May 6, 2019

Re: Falcon Marketplace Final Plat (SF-19-001 CDR-16-007)

Please accept this response letter to your comments dated February 14, 2019

SIGNAGE & STRIPING PLAN

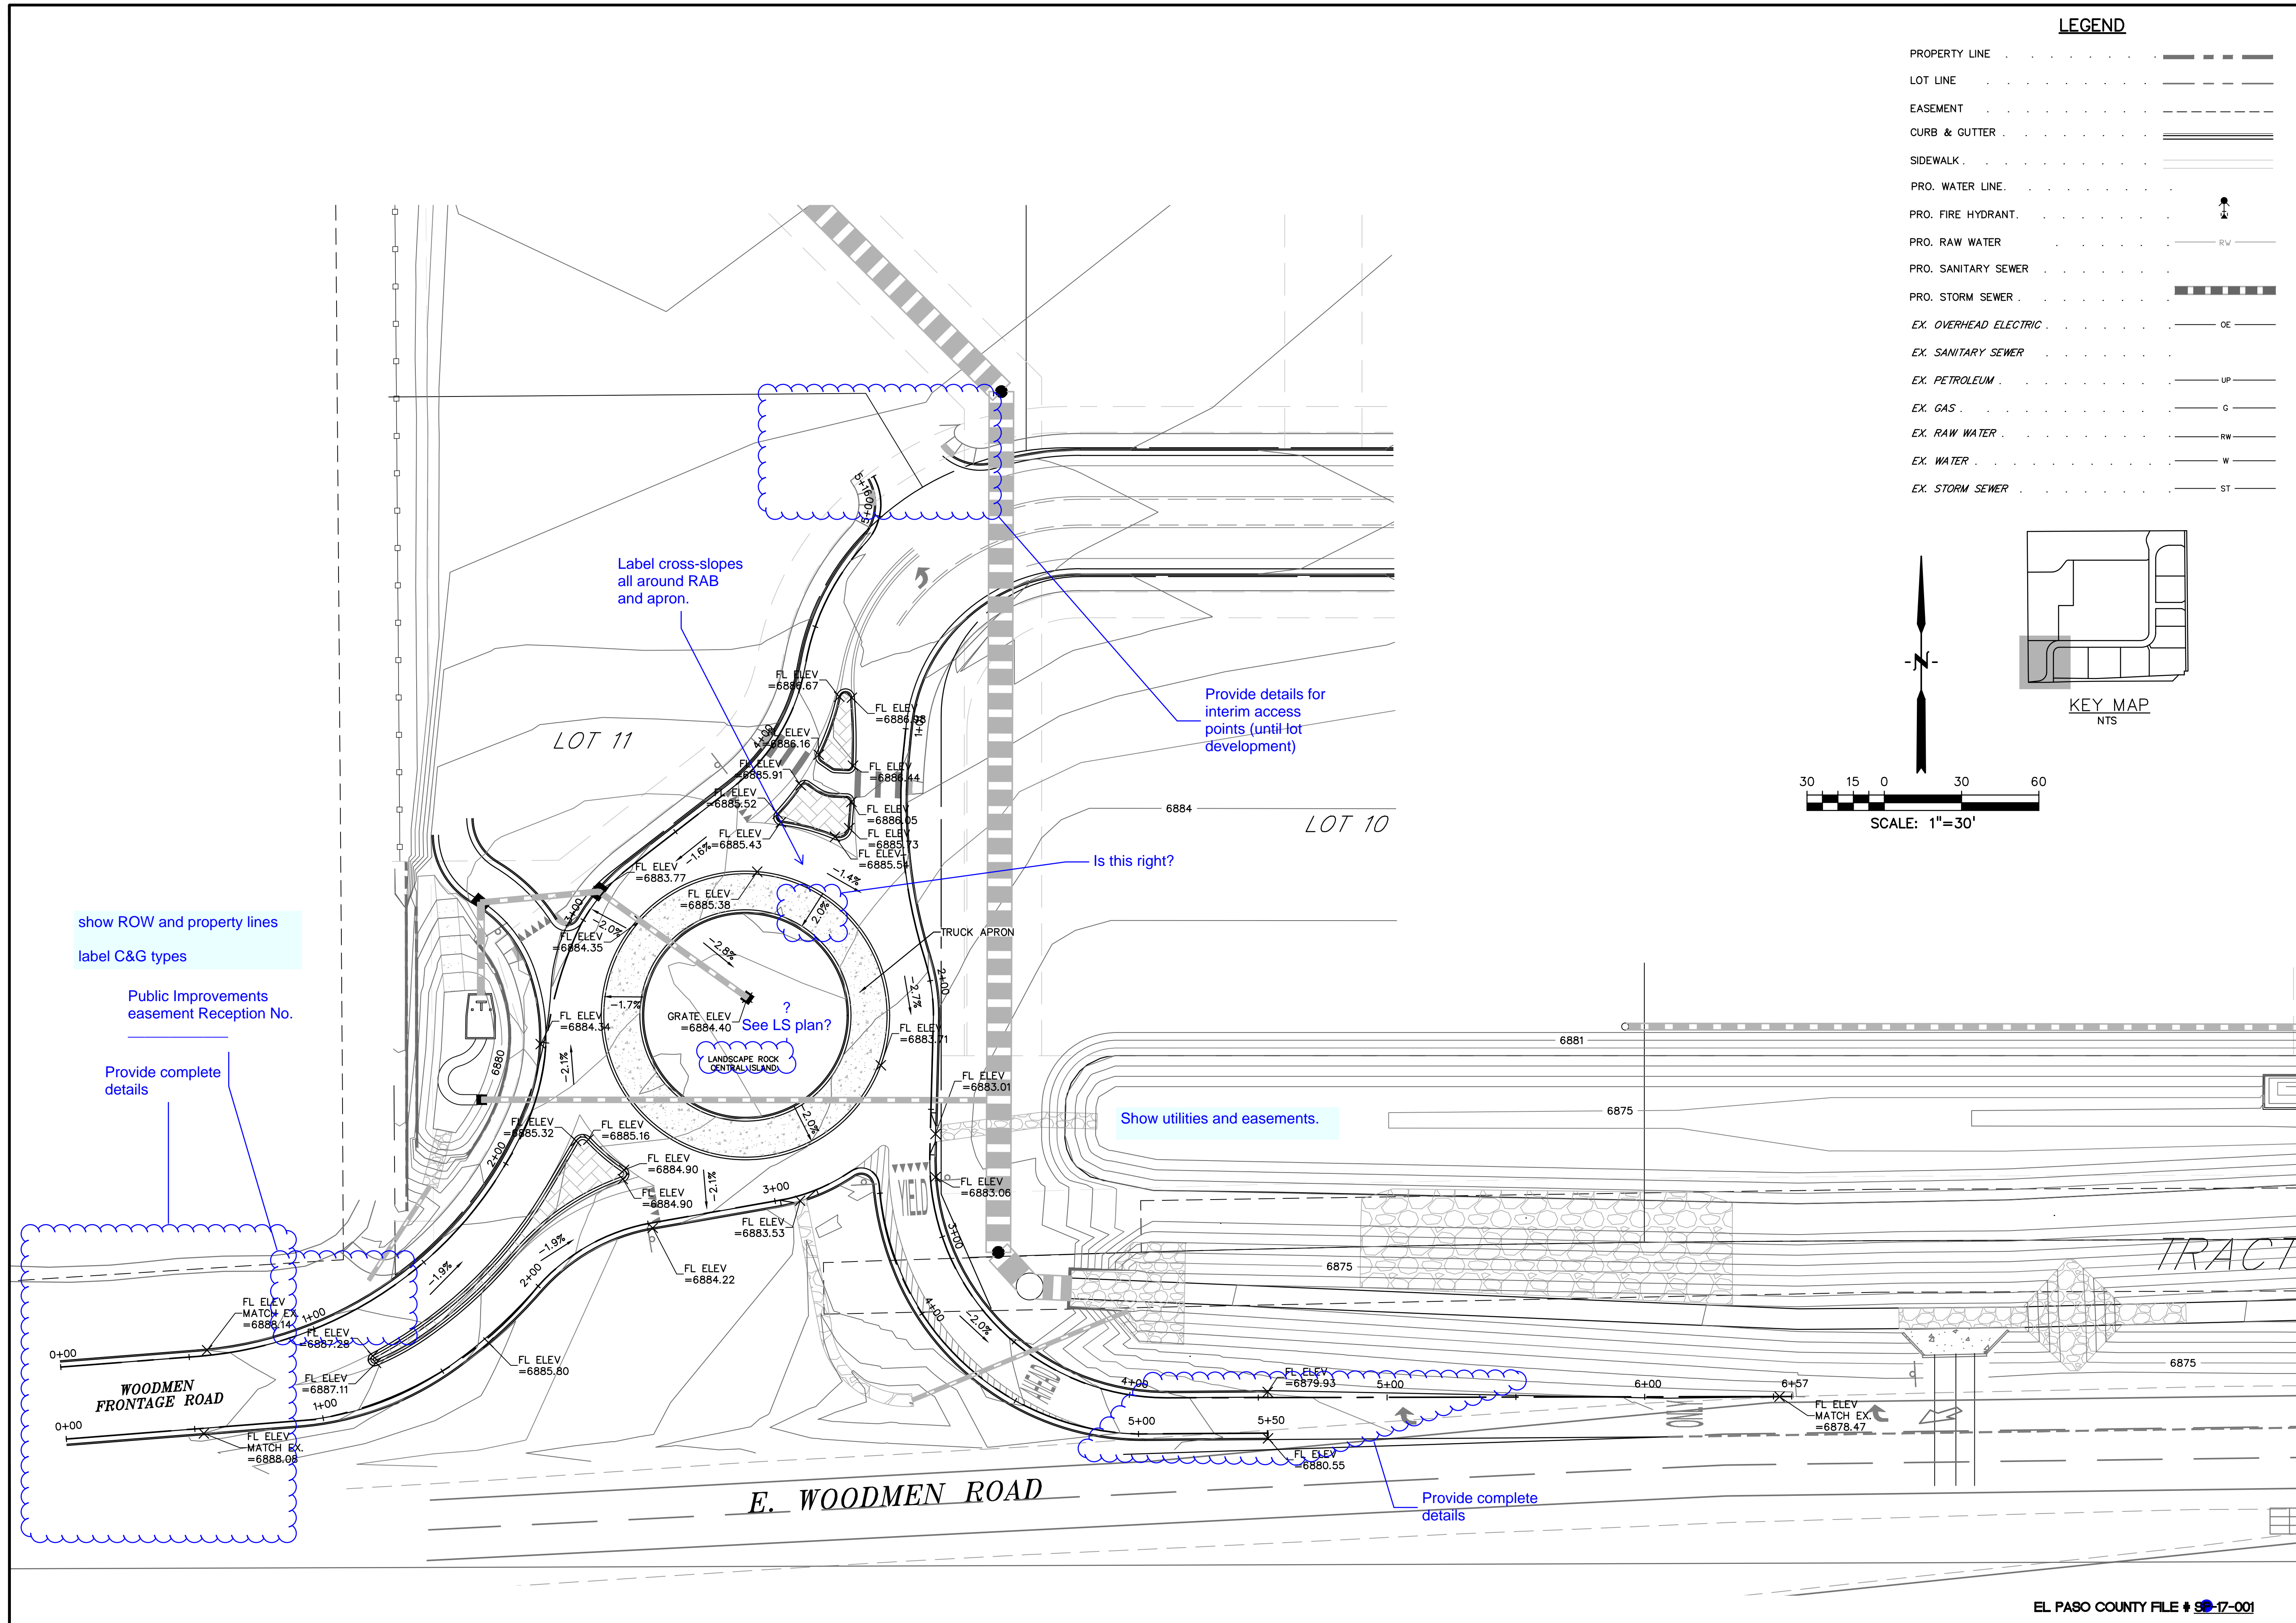
4. ****(9) Regarding Figure 26, one Right Lane Must Turn Right sign should be sufficient and suggest retaining only the upstream sign with the 500-ft plaque and adding two***

R3-5 signs adjacent to the arrow pavement markings. Suggest adding a Circular Intersection warning sign in place of the Yield Ahead sign. **Verify on signing and striping plan. Signage and striping plan updated as requested.**

**STORM SEWER
PLAN &
PROFILE**

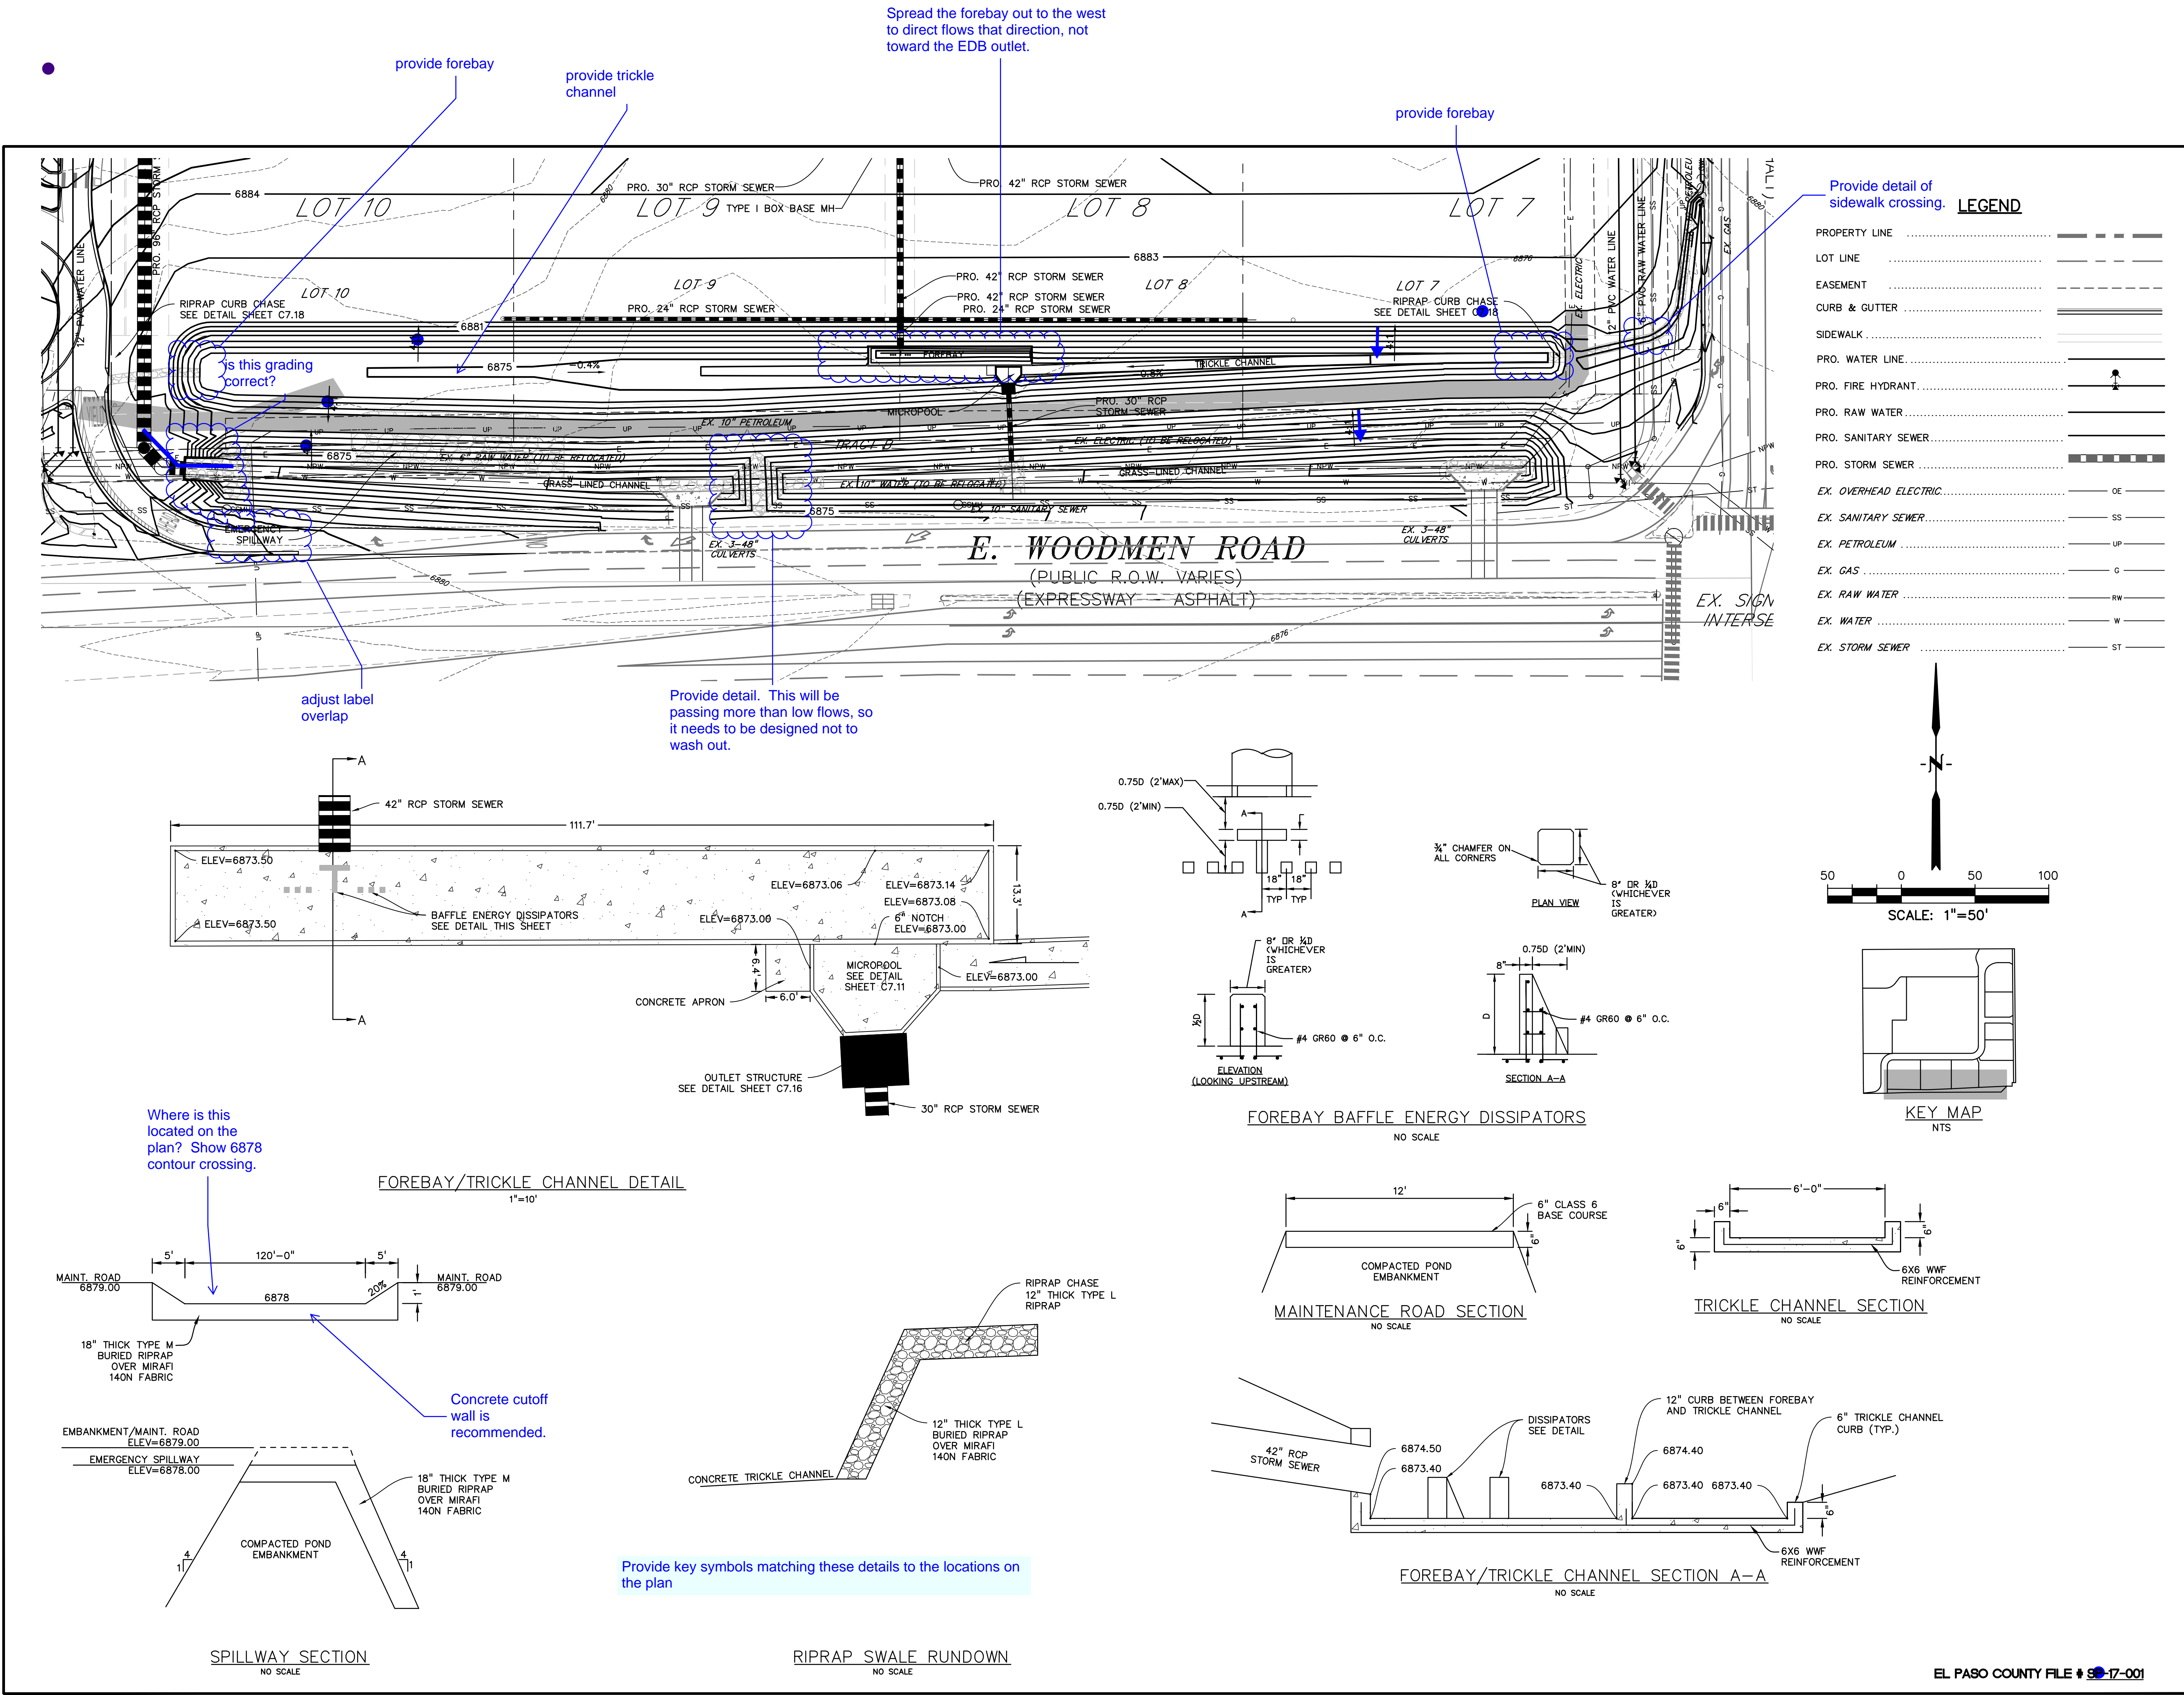
- c. Consider replacing the proposed area drain and pipe at the northwest corner with a swale along the north property line to the proposed rundown. Maintenance access appears likely to be difficult as proposed and the geotech. study recommends "properly designed drainage swale" at the tops of excavation slopes.

- Partially resolved; stabilization of and maintenance access to the 3:1 (and steeper?) excavated slope along the north side of Pond SR4 will need to be further addressed with the final pond design. (If the extent of overlot grading includes the slopes, this needs to be addressed with overlot grading.) Comment remains; access road design, offsite grading (requiring easements) sheet flow locations and rundowns and the concrete rundown need additional detail to ensure adequate access and functioning. Unresolved. Partially resolved; see remaining redlines. Partially resolved; see updated redlines. Additional details regarding the pond inflow area, including offsite easements, are required. Provide options analysis regarding geocells and articulated mats when available. Partially resolved; additional details and easements need to be resolved prior to construction. Provide when available; include options analysis in the FDR. Cost analysis to follow.*
